February 9, 2017

RE: **Bruno Residence**
8001 Fuji Court
Grading Plan
Engineer's Stamp Date 2/1/17 (File: E10D029)

RE: **Bruno Residence**
8001 Fuji Court
Grading Plan
Engineer's Stamp Date 1/13/17 (File: E10D029)

Based upon the information provided in your submittal received 01/13/2017, the Grading Plan is not approved for Building Permit. The following comments need to be addressed for approval of the above referenced project:

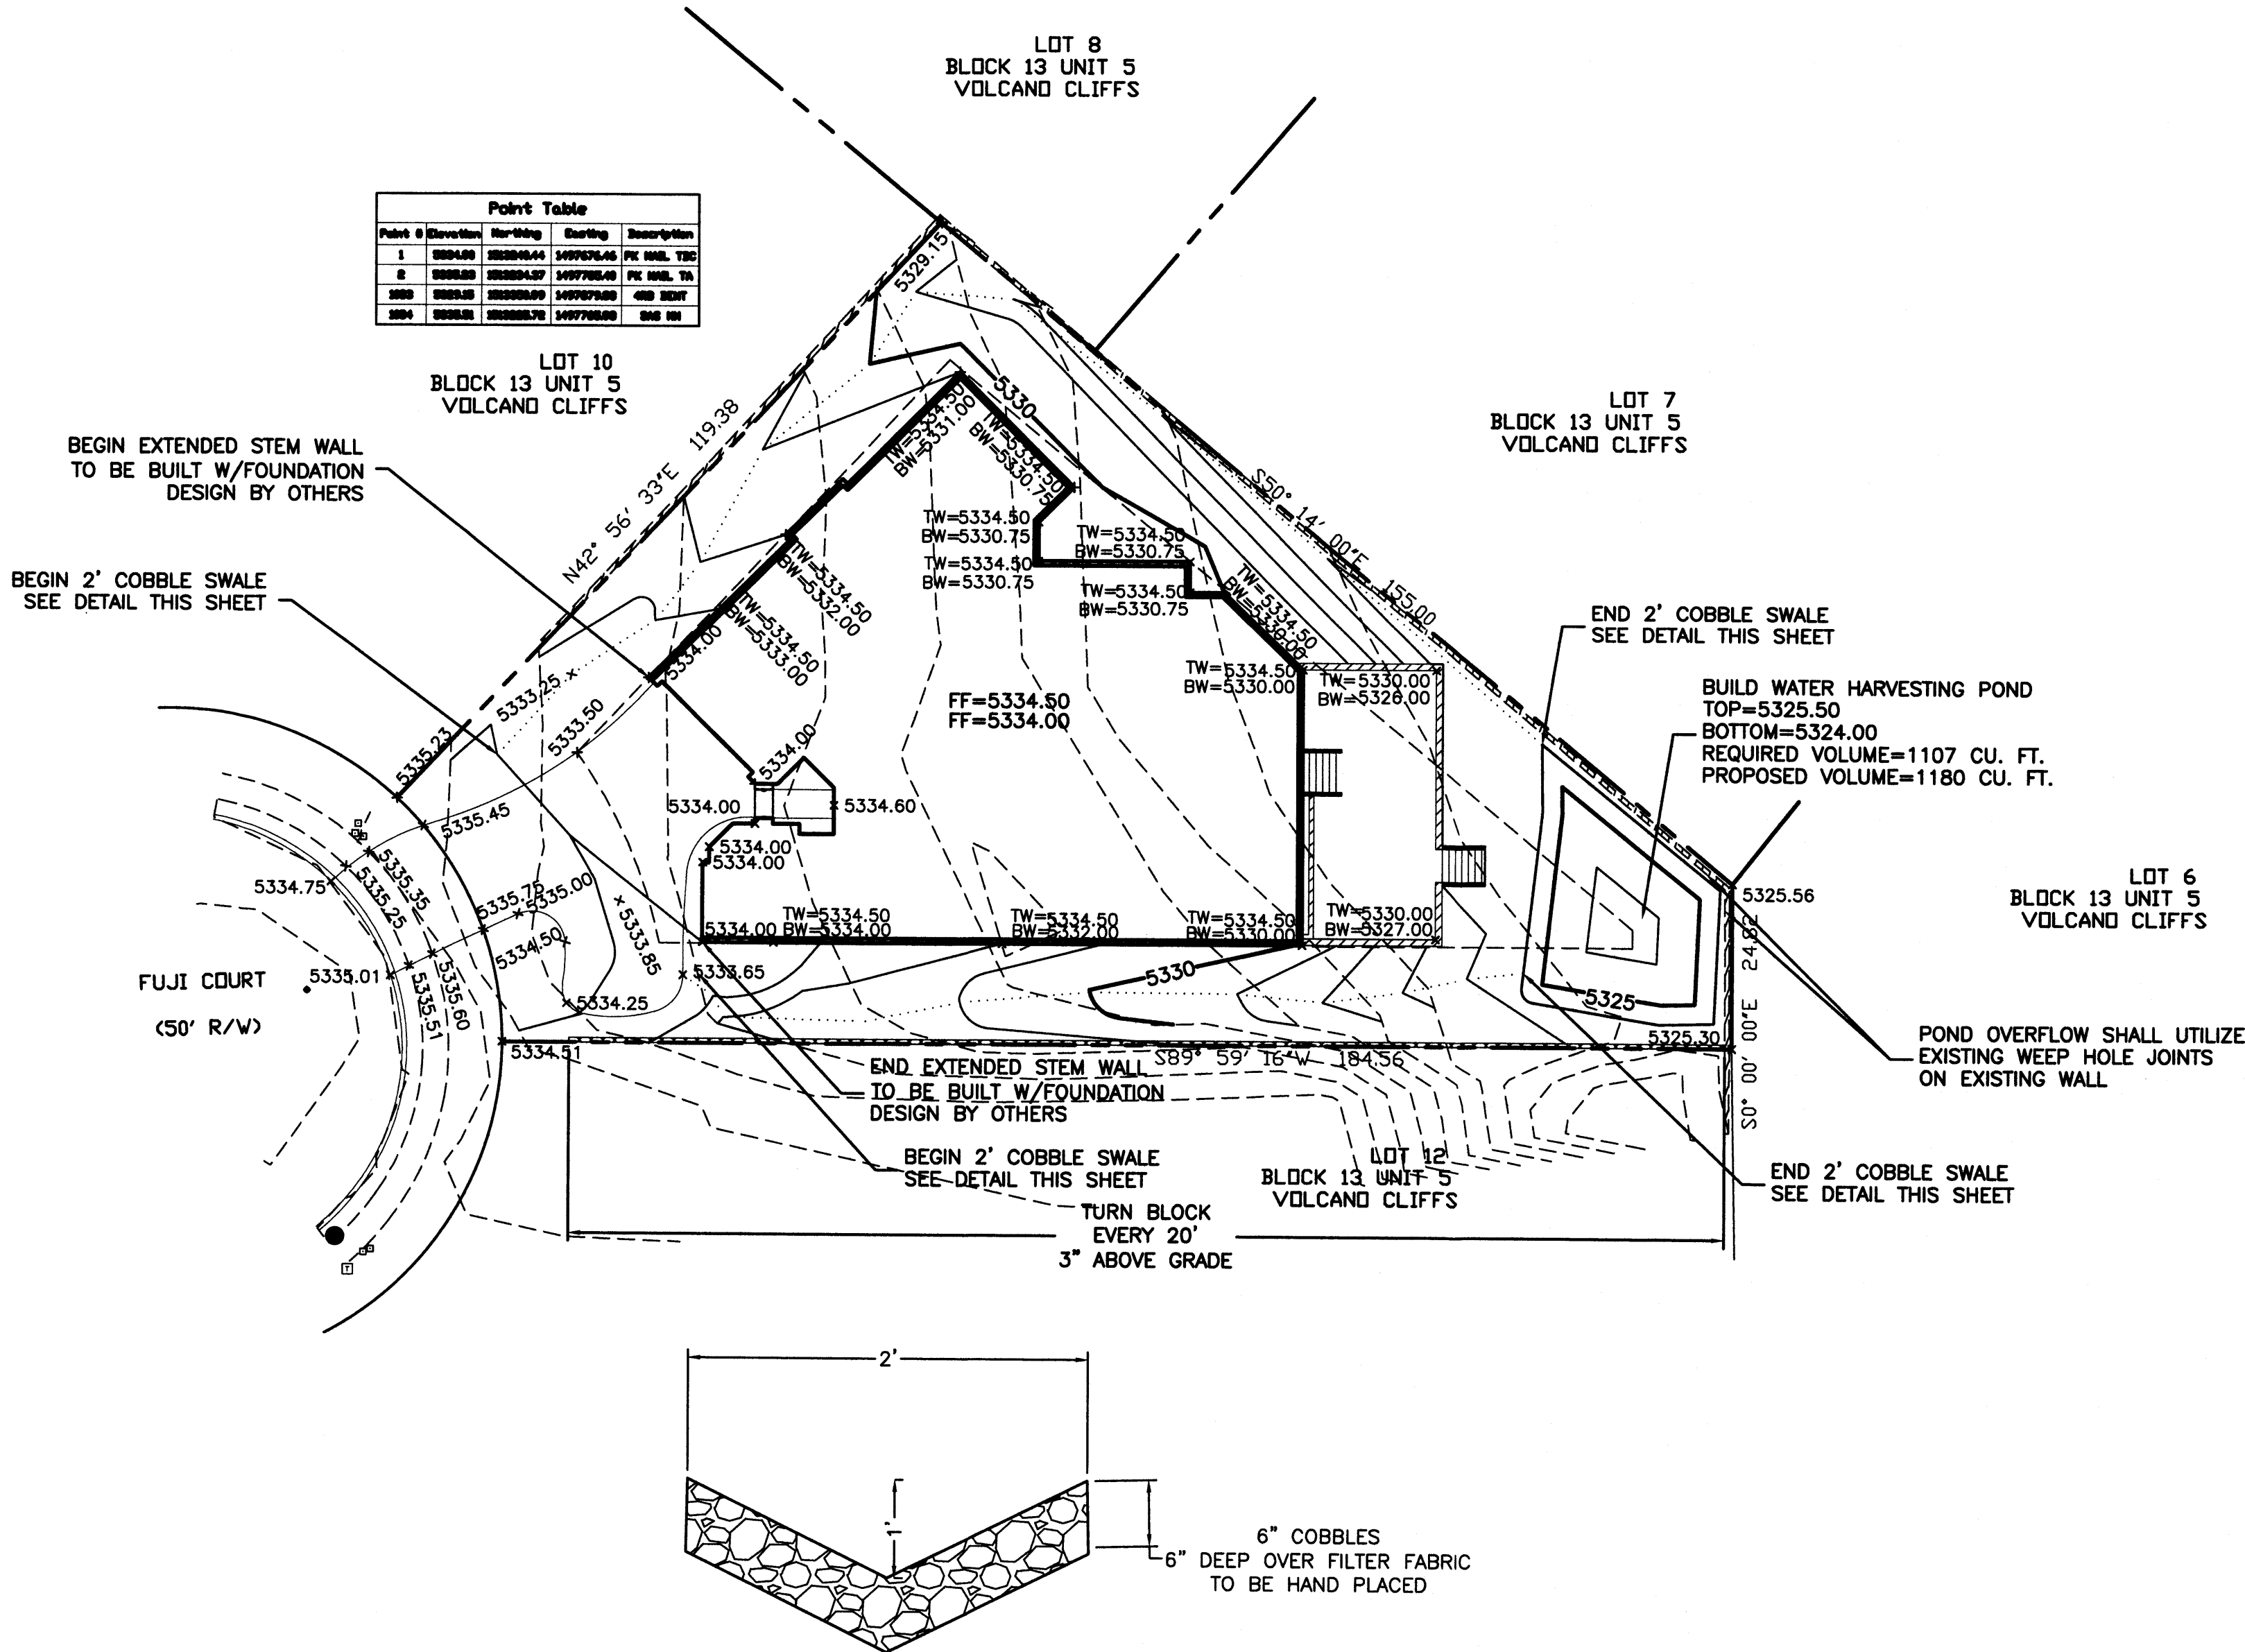
1. For historic flowpaths to adjoining lots, retain at least 50% of the proposed conditions 100-year, 24-hour event. Currently the pond is sized to hold only 633 cubic feet. **WE HAVE RETAINED 50% OF THE 100-YEAR, 24-HOUR VOLUME**
2. This site is within Special Assessment District 227, not 226, update the narrative to reflect. **WE HAVE CORRECT THE NARRATIVE**
